CITY OF ALBUQUERQUE

**RE: West central Plaza Addition
Conceptual Drainage and Grading Plan
Engineer's Stamp Date ~~3-28-2016~~ (File: K12D015B)**

Based upon the information provided in your submittal received 12-1-2016, the above referenced plan is approved for Building Permit.

SHEET TITLE
CONCEPTUAL DRAINAGE MGMT PLAN

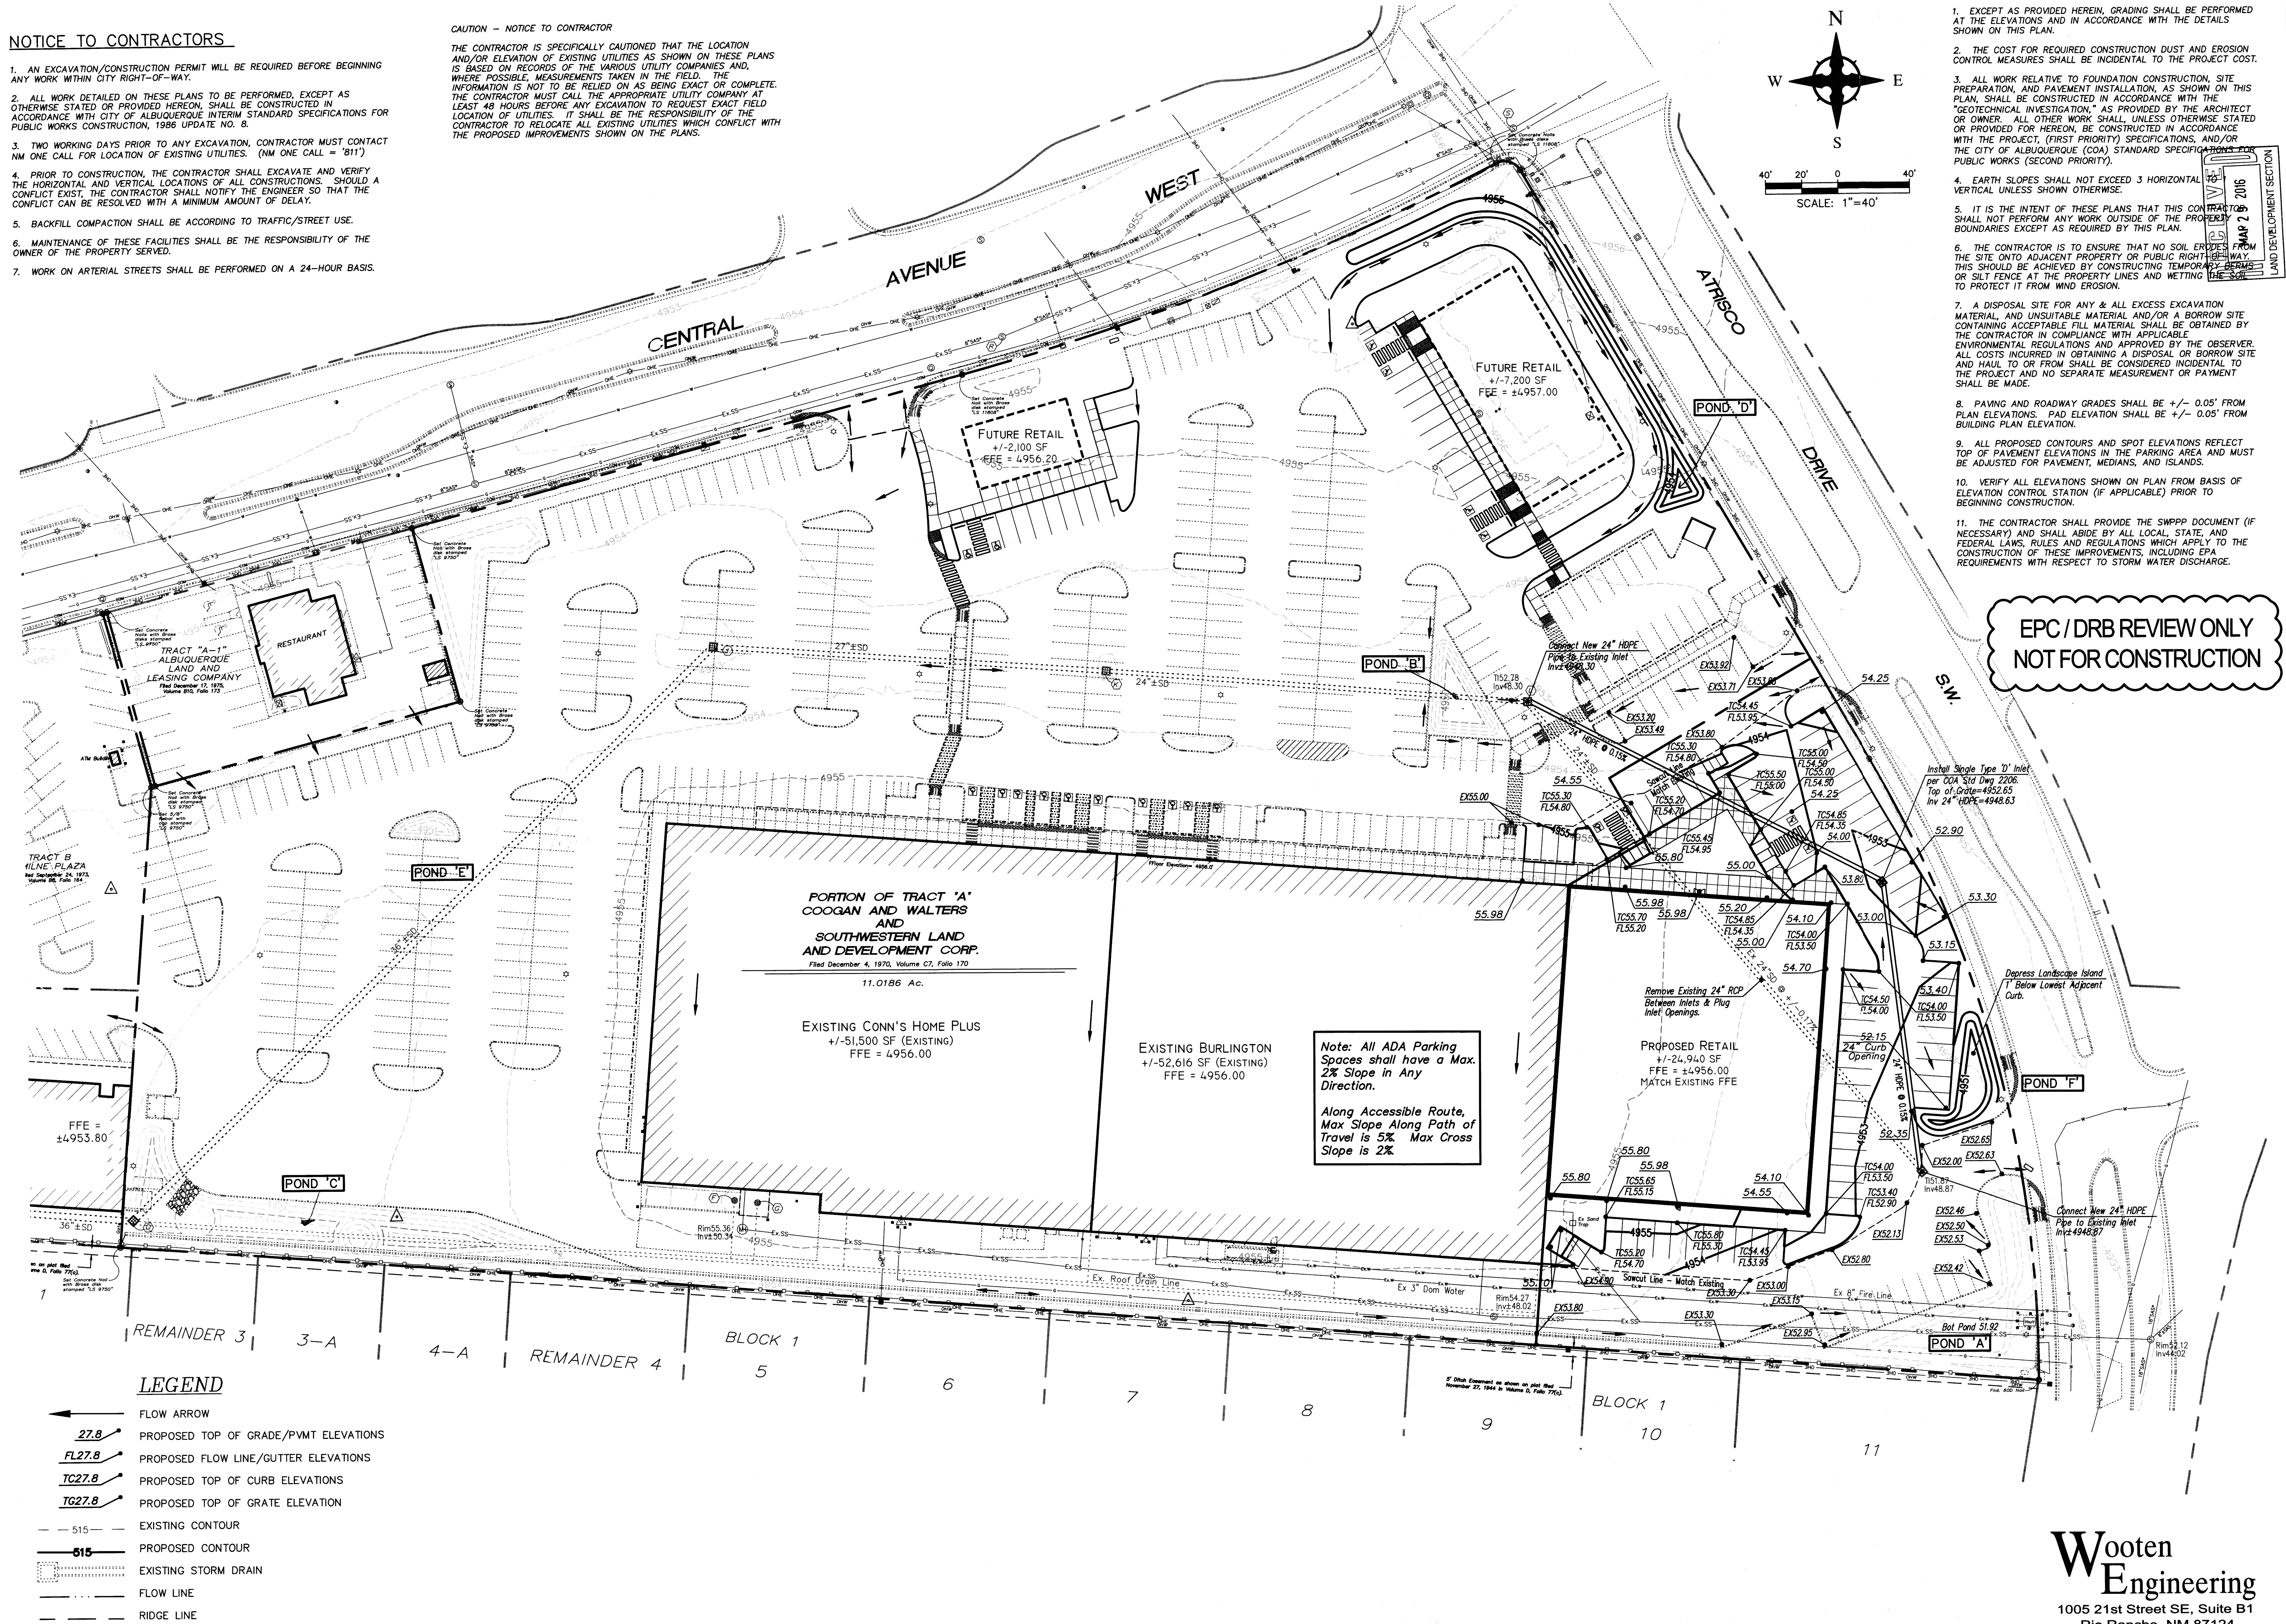
I recommend considering aligning the new storm drain with the access aisles within the parking lot, but it is not a requirement.

| SHEET TITLE DRAINAGE MANAGEMENT PLAN | | DATE 3/28/2016 | |

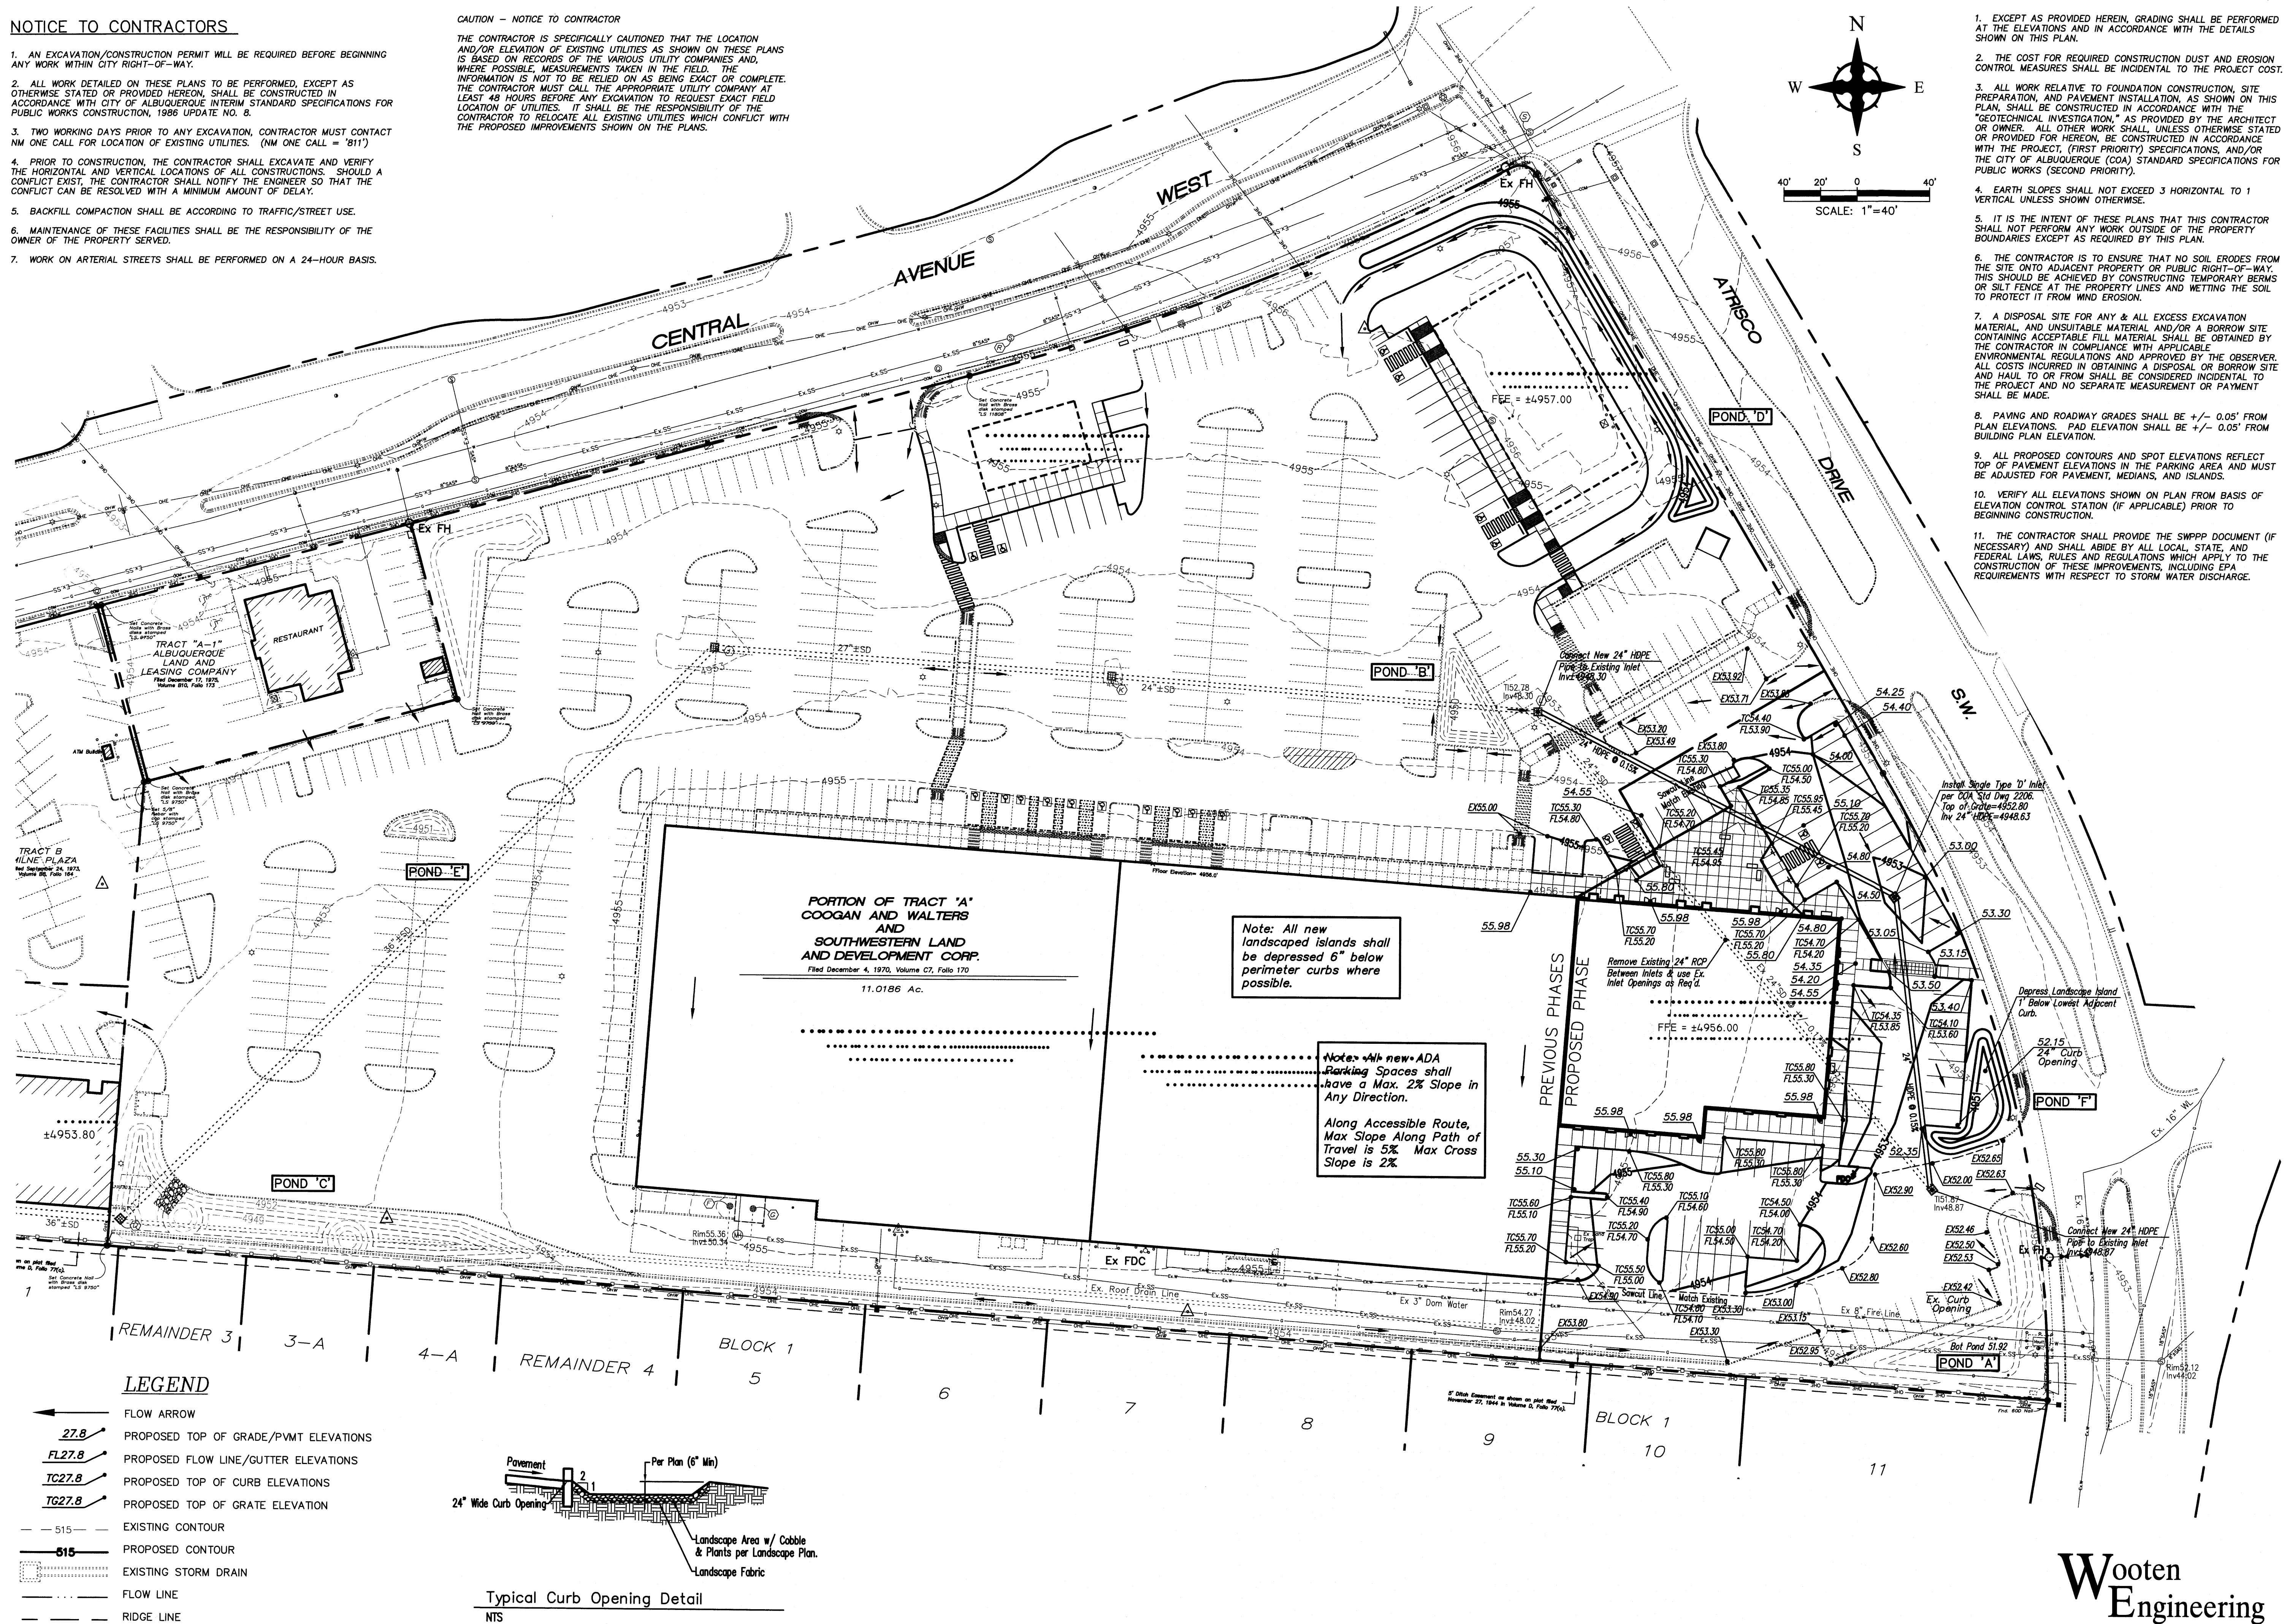
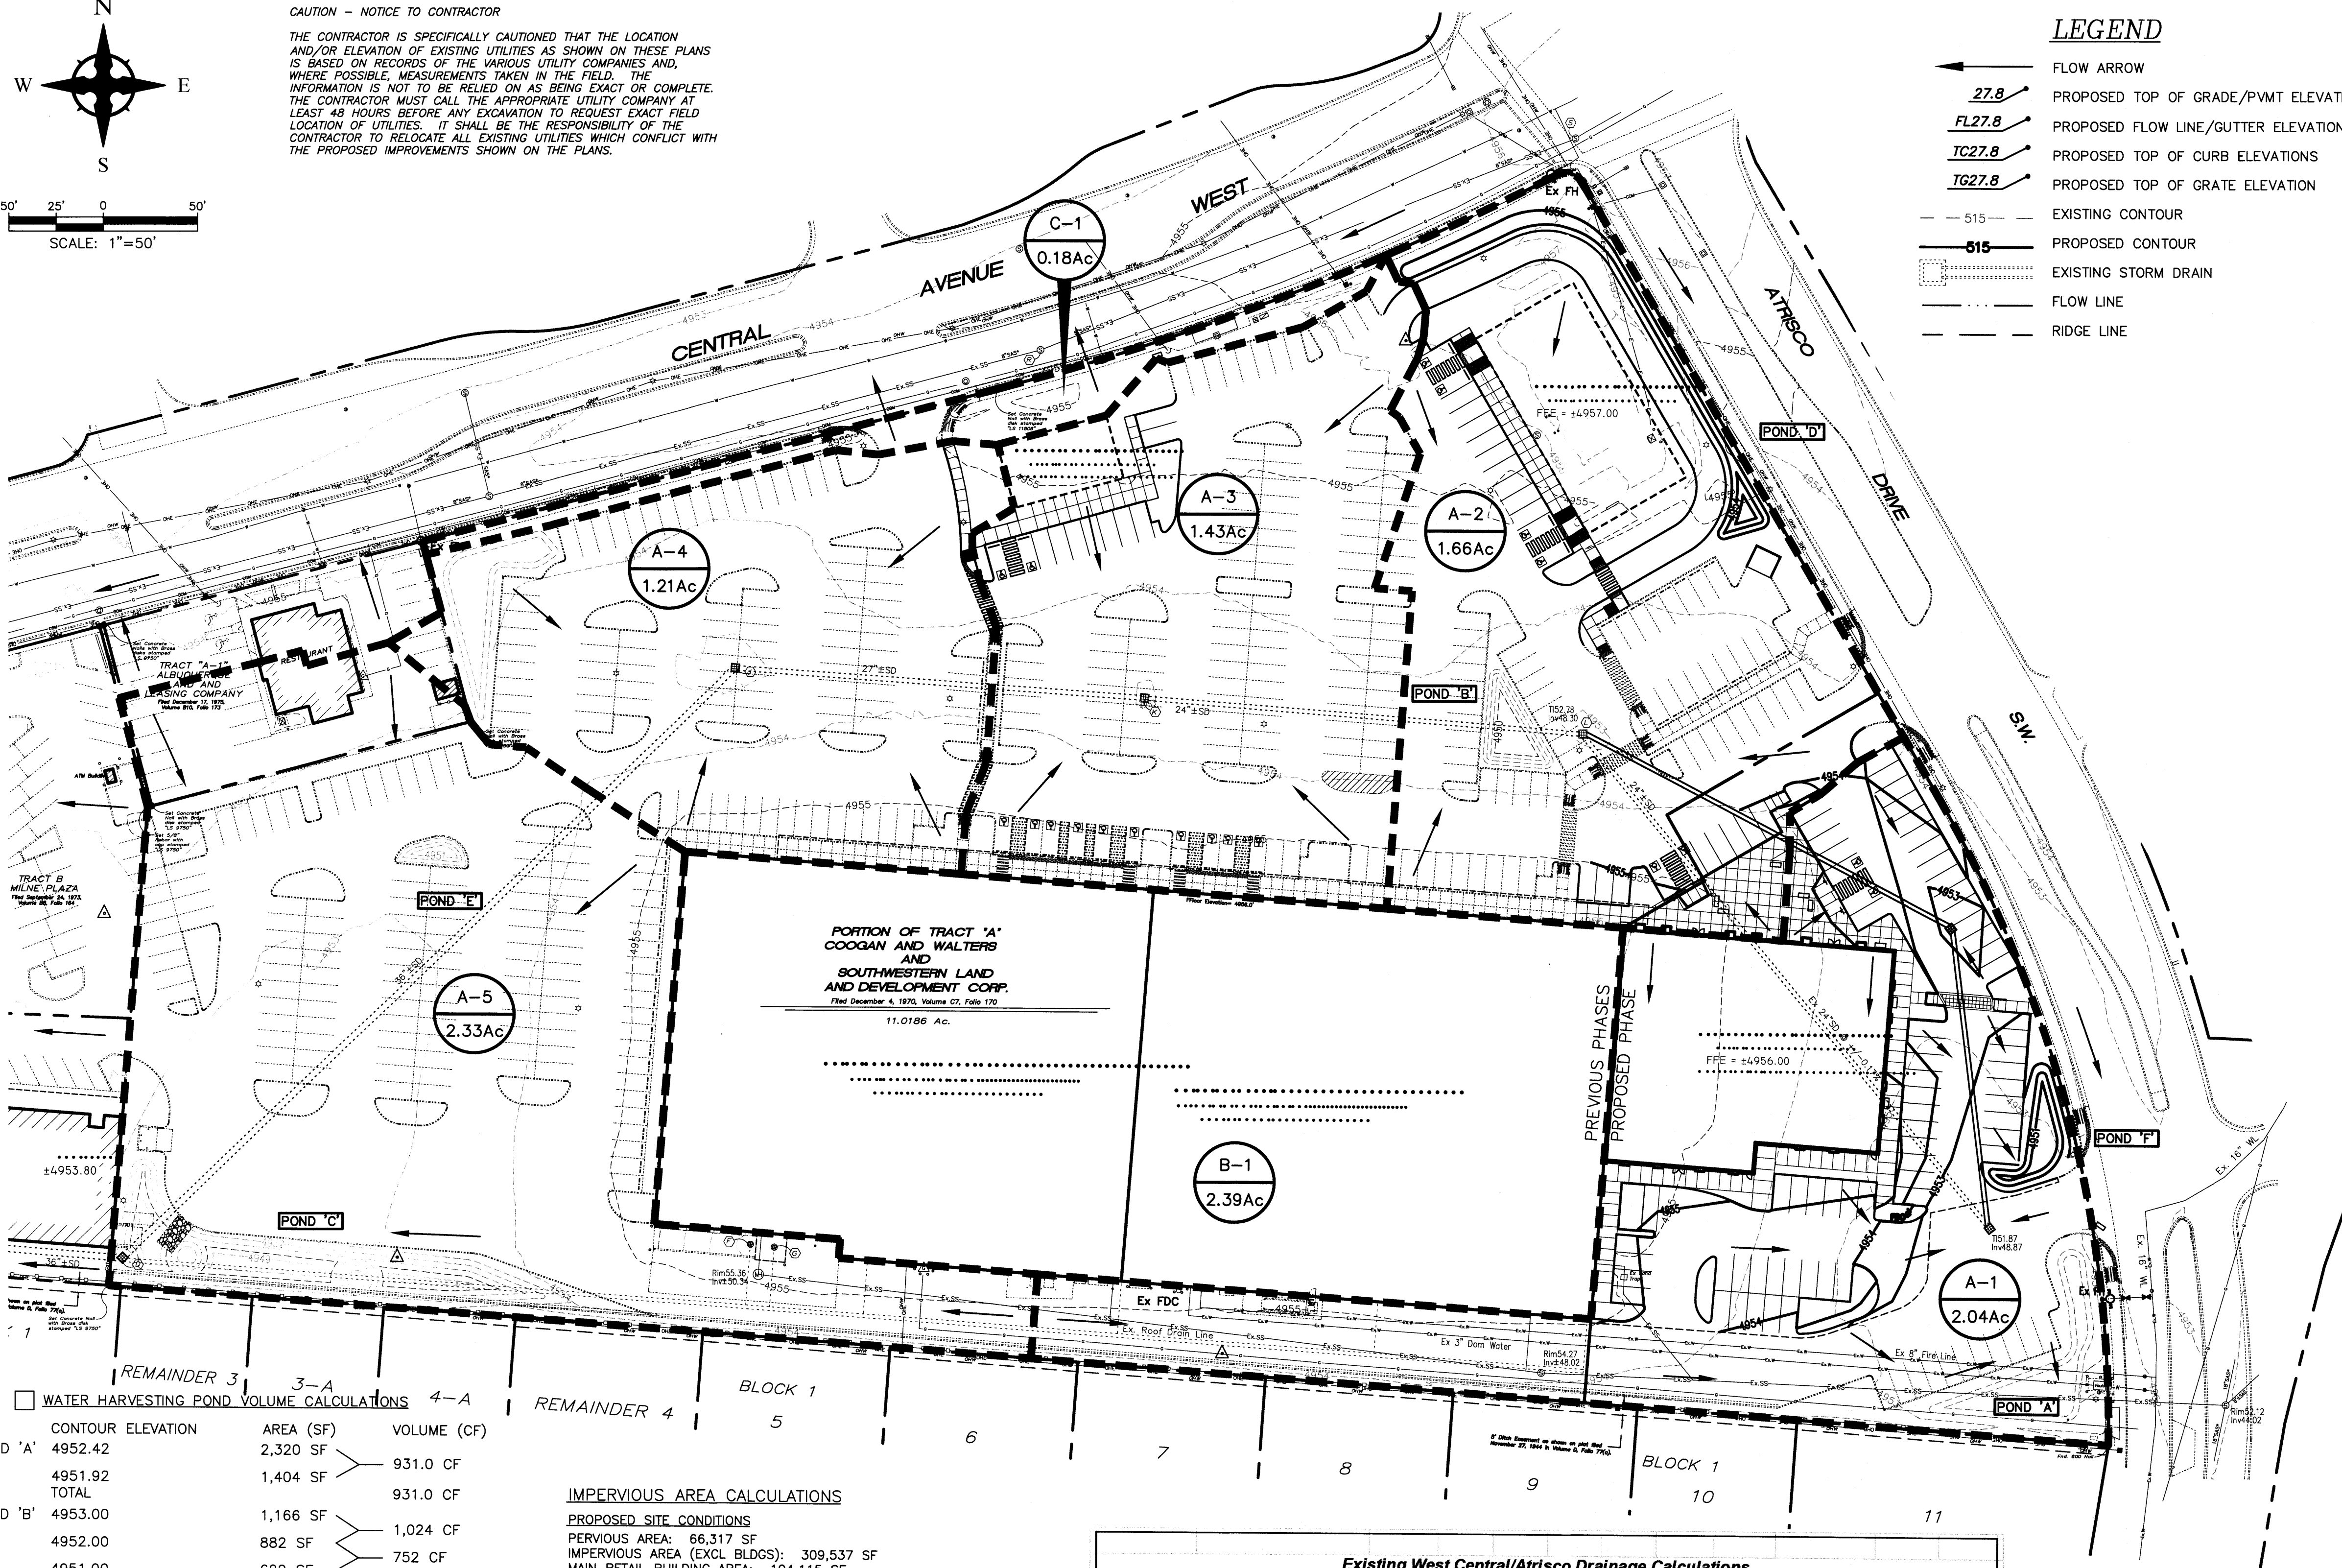
On the certification, please ensure that the land treatment distribution for the proposed condition is correct.

For example basin B-1 is assumed to be 13.4% C and 86.4% D, but it should be 100% D .
The minor discrepancy does not appear to affect the sizing of the facilities, however.
